from
**Southern
Water**

Date
21/08/2020

Proposal: Approval of details reserved by condition imposed under Y/1/17/OUT for conditions 5-programme of archaeological work; 6-landscape & layout particulars; 7-Ecological Enhancement and Management Scheme; 8-tree protection measures; 11-exact position of surface water sewer; 12-proposed surface water drainage scheme; 14-maintenance and management of SuDS system; 16-drainage strategy; 17-Soil Resources Plan; 20-Construction Management Plan & 23-lighting strategy.

Site: Y/59/20/DOC: - Bonhams Field, Main Road, Yapton BN18 0DX.

CLIENT	Seaward Properties Limited				
PROJECT	Bonhams Field, Main Road, Yapton				
TITLE	Site Layout Proposed Drainage Plan				
DRAWN	M Pacifico		DATE	May 2019	
ENGINEER	S Magowan		CHECKED	SRM	
SCALE	1:500 @ A1 / :1000 @ A3				
			PROJECT NO.	23018	
			DWG No.	1210	REV. D

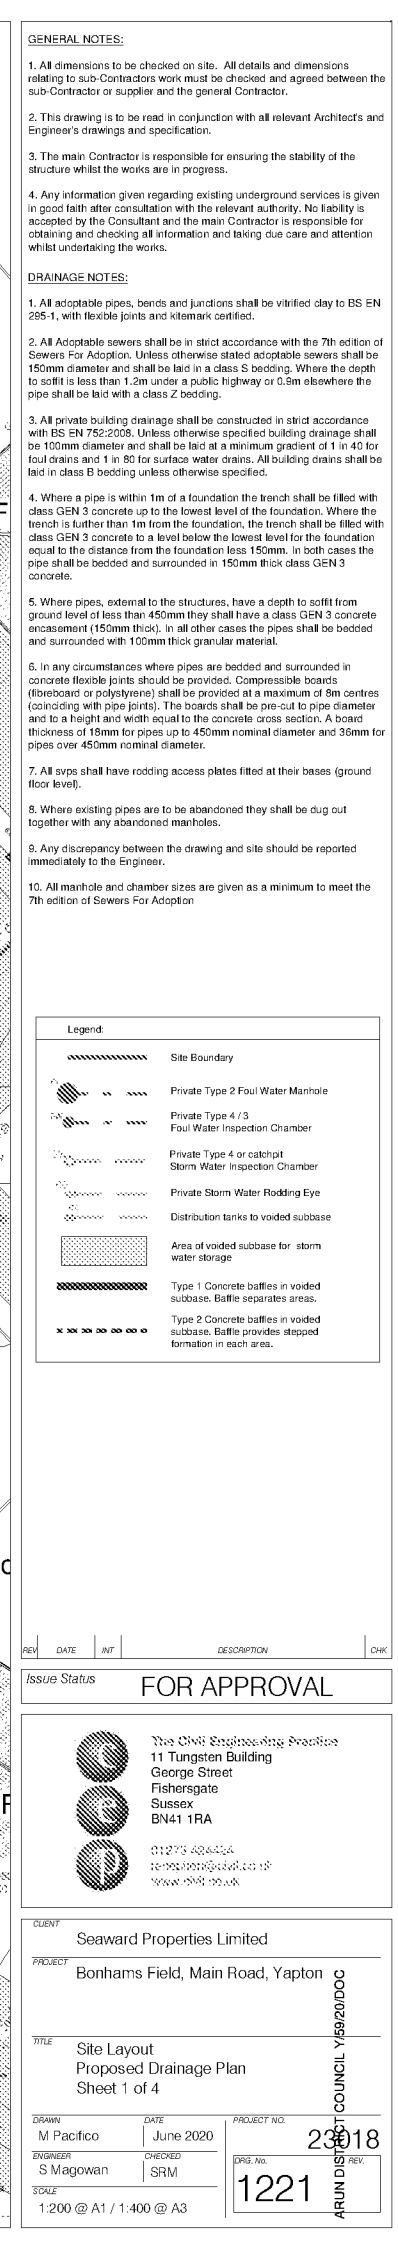
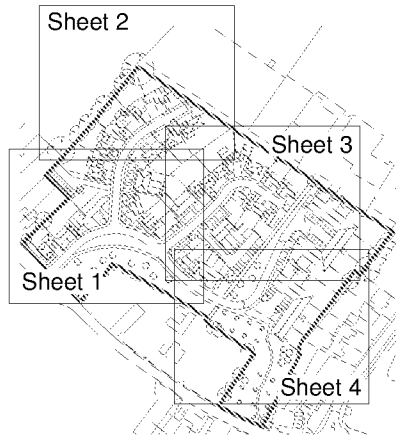
Southern Water cannot recommend discharge of Condition 11, 12 and 14 relating to surface water drainage. The submitted drainage layout shows (23018-1210-Rev-D) soakaway are located within the required minimum distance of 5 meters from the proposed development. Any soakaway for the disposal of storm water must be at least 5 meters from the dwelling to comply with building regulation.
